Rezoning Transportation Analysis

Petition Number: 2021-132

Date	Description
09-17-2021	First Review (WB)
10-18-2021	Second Review (WB)
10-18-2021	Third Review (WB)

REZONING PLAN
RZ.01

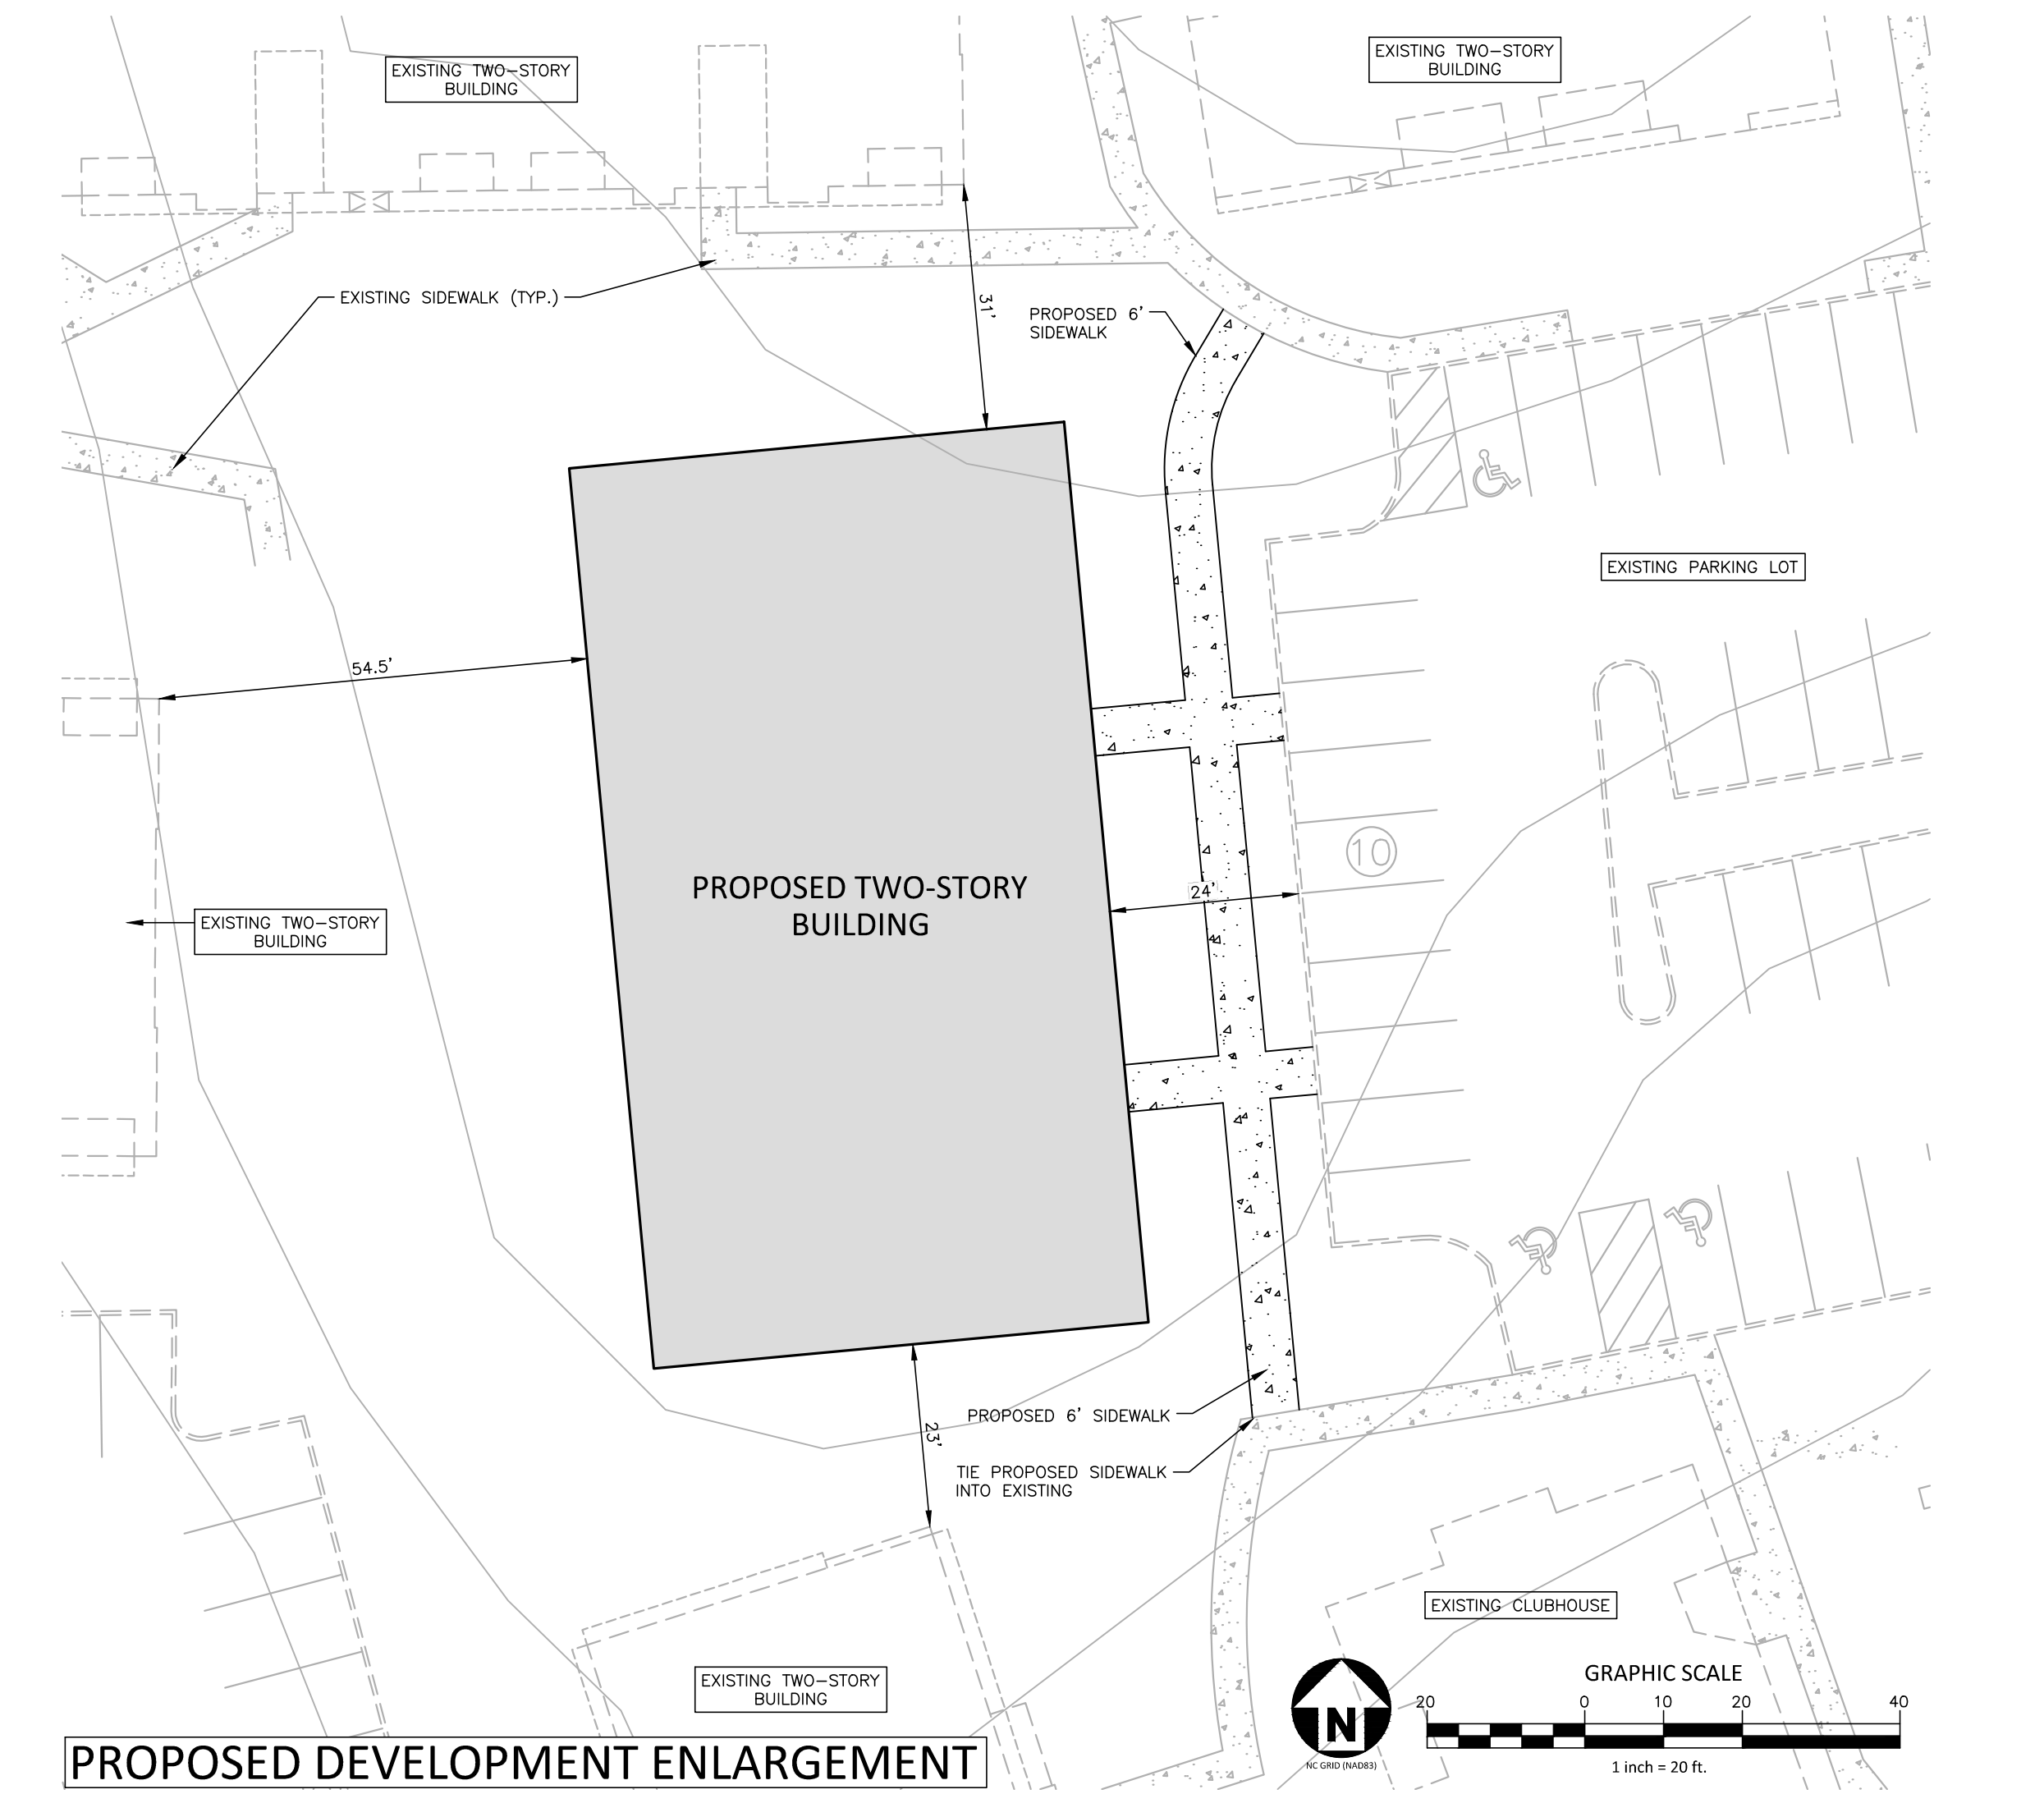
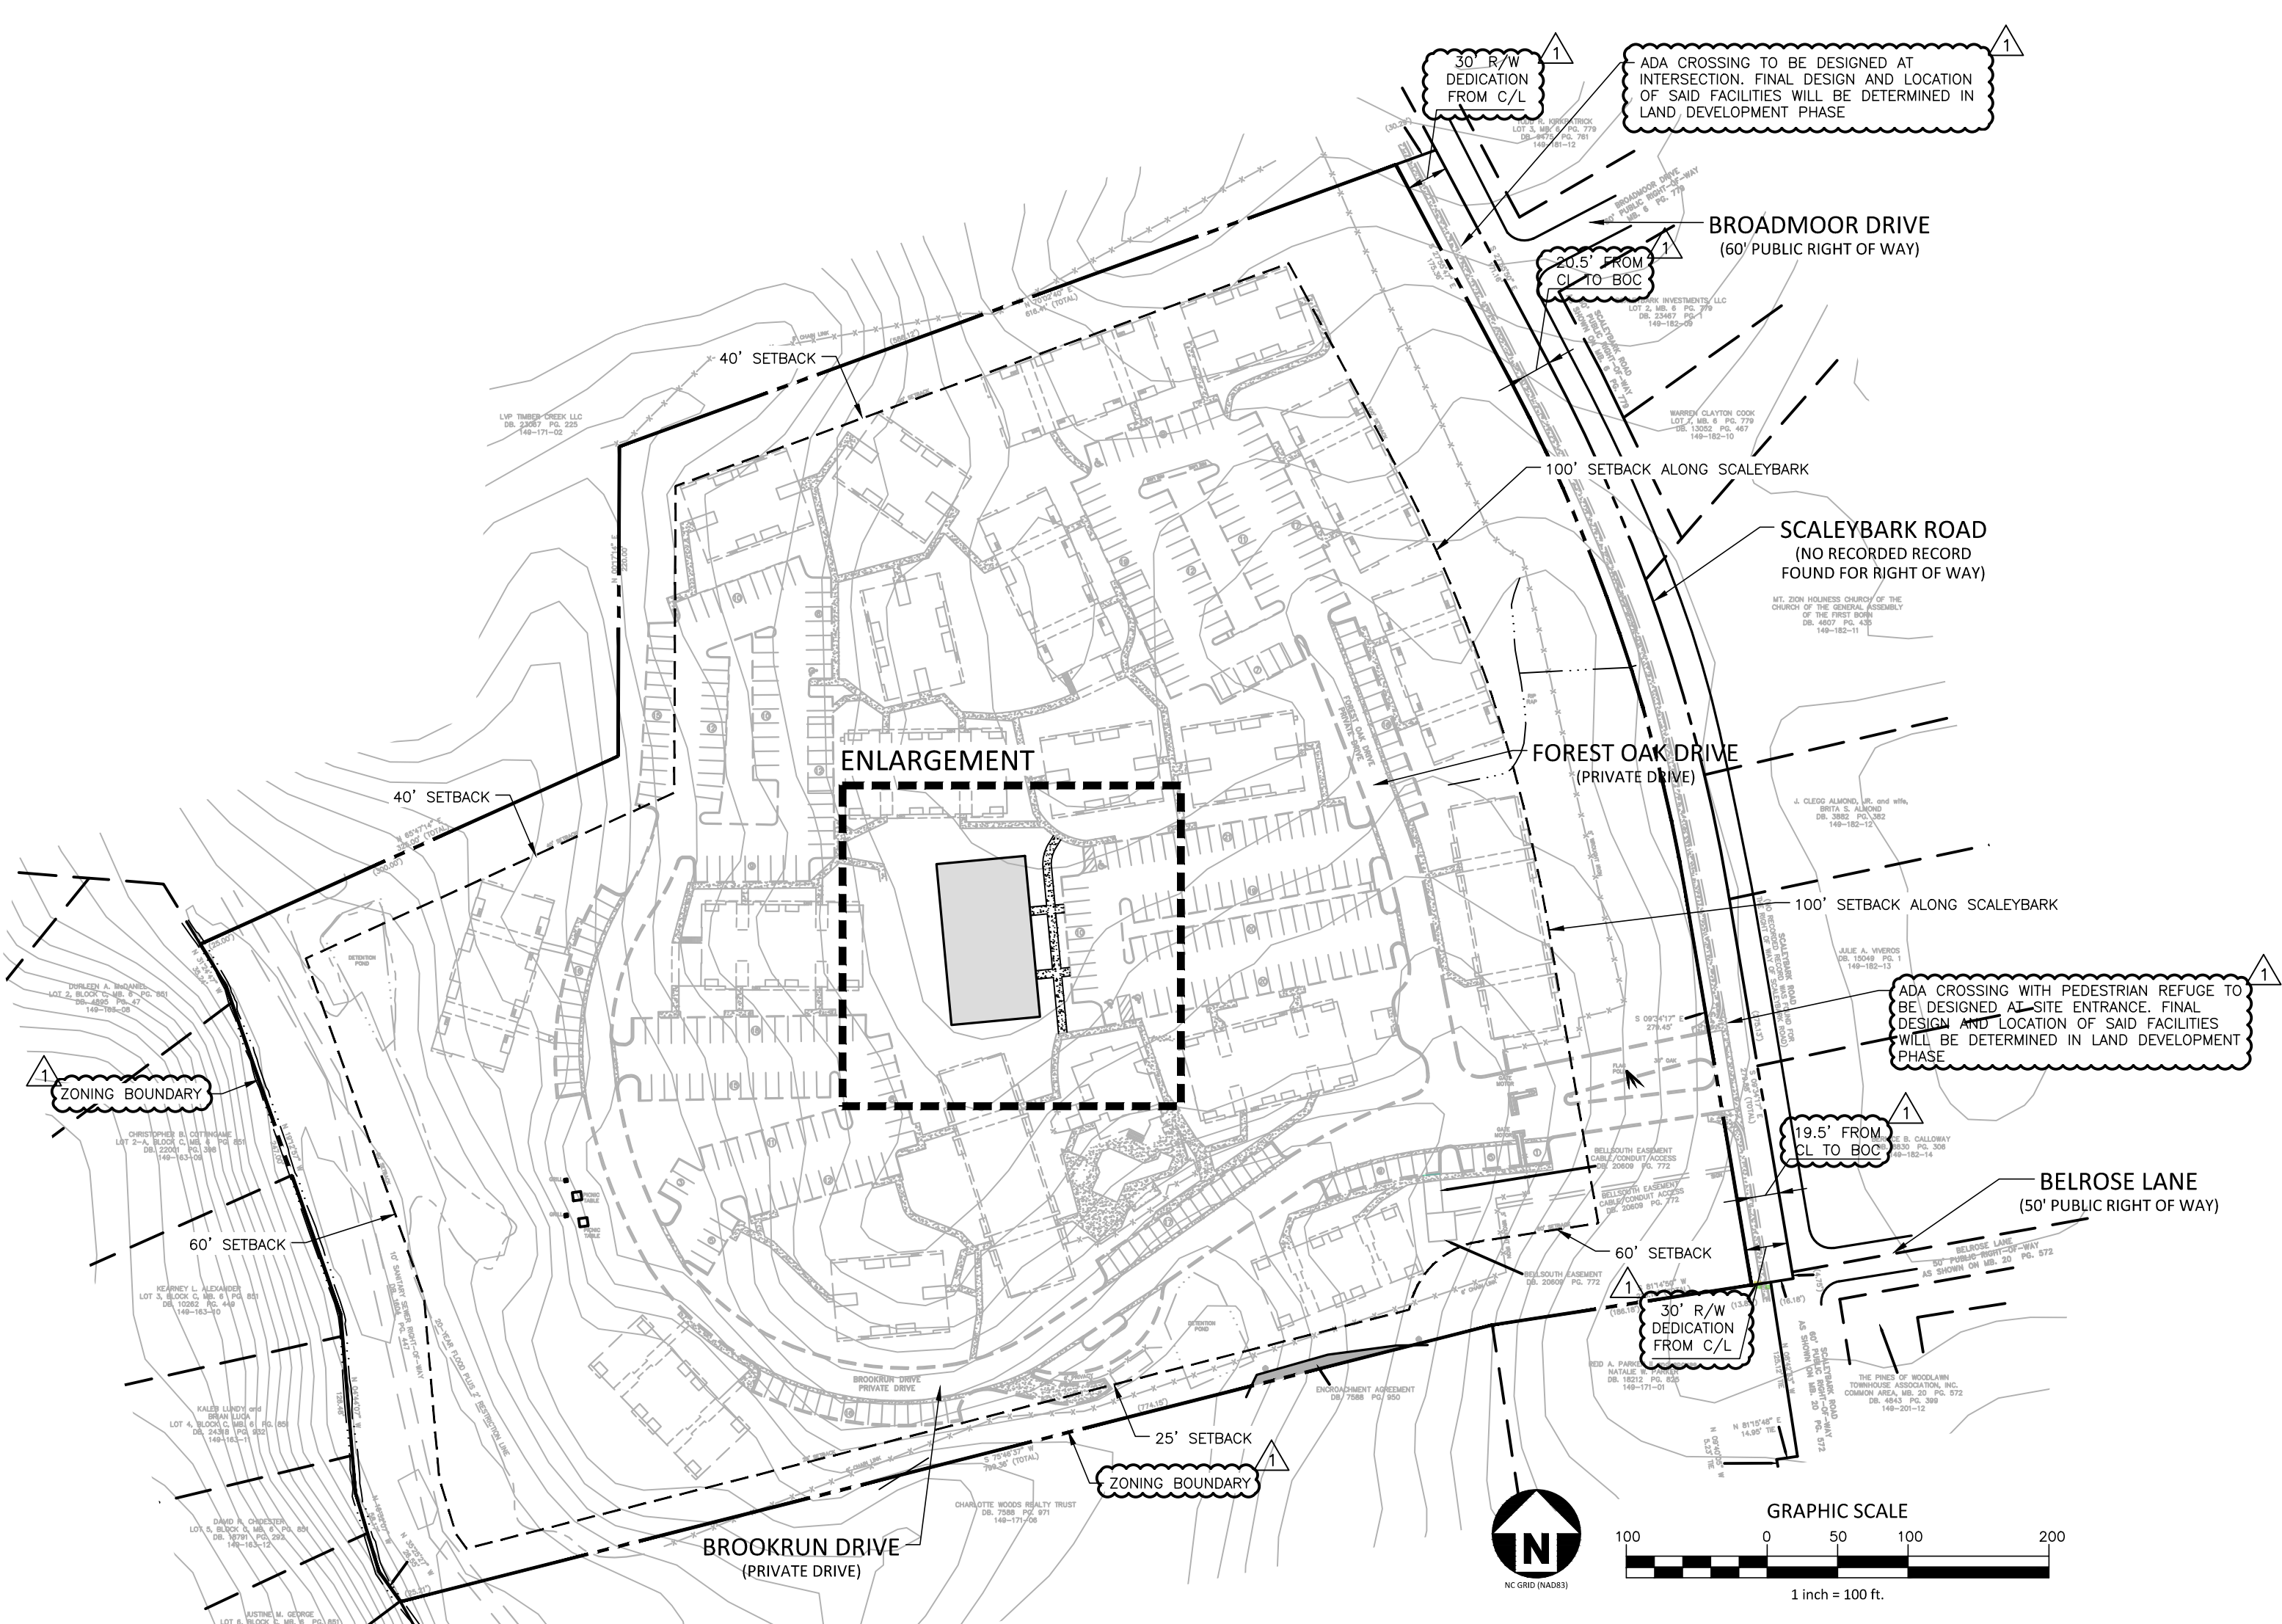
5. The proposed dwelling units exceeds 12 per acre. Per Chapter 20 Subdivision ordinance, site plan and conditional note(s) revisions are needed to commit to construct an 8-foot sidewalk with 8-foot planting strip along Scaleybark Road. The wider sidewalk meets the Charlotte WALKS Policy. The site plan shall label and dimension both items from the back of curb.

Technical Clarification (10/18/2021) Conditional notes to be updated to state that “The Petitioner will remove and replace the existing substandard sidewalk at the back of curb to meet CDOT standards per Chapter 20 to the City’s Ordinances.”

e. The Petitioner will dedicate, via fee simple conveyance, along the Site's frontage on Scaleybark Rd. 30-foot of right-of-way as measured from the existing center line of Scaleybark Rd. as generally depicted on the Rezoning Plan. The additional right-of-way will be dedicated prior to the issuance of the first certificate of occupancy. The Petitioner will provide a permanent sidewalk easement for any portion of sidewalk located along the public streets located outside of the right-of-way. The permanent sidewalk easement will be located a minimum of two (2) feet behind the sidewalk where feasible.

f. The Petitioner will install ADA compliant crossing facilities at the existing T intersection of Scaleybark Rd. and Broadmoor Drive and at the intersection of Site's main access on Scaleybark Rd., as generally depicted on the Rezoning Plan. The Petitioner will also modify the existing concrete island in Scaleybark Rd. at the Site's main entrance so that it can function as an additional pedestrian refuge island. Existing crossing facilities that meet ADA standards will not need to be replaced. These proposed improvements will be provided prior to the issuance of the first certificate of occupancy.

g. The Petitioner will replace the existing sidewalk along Scaleybark Rd. with a new sidewalk and planting strip if the existing sidewalk is required to be replaced by Chapter 19. The width of the sidewalk and the width of the planting strip to be determined during the land development approval process for the Site based on the requirements of Chapter 19.
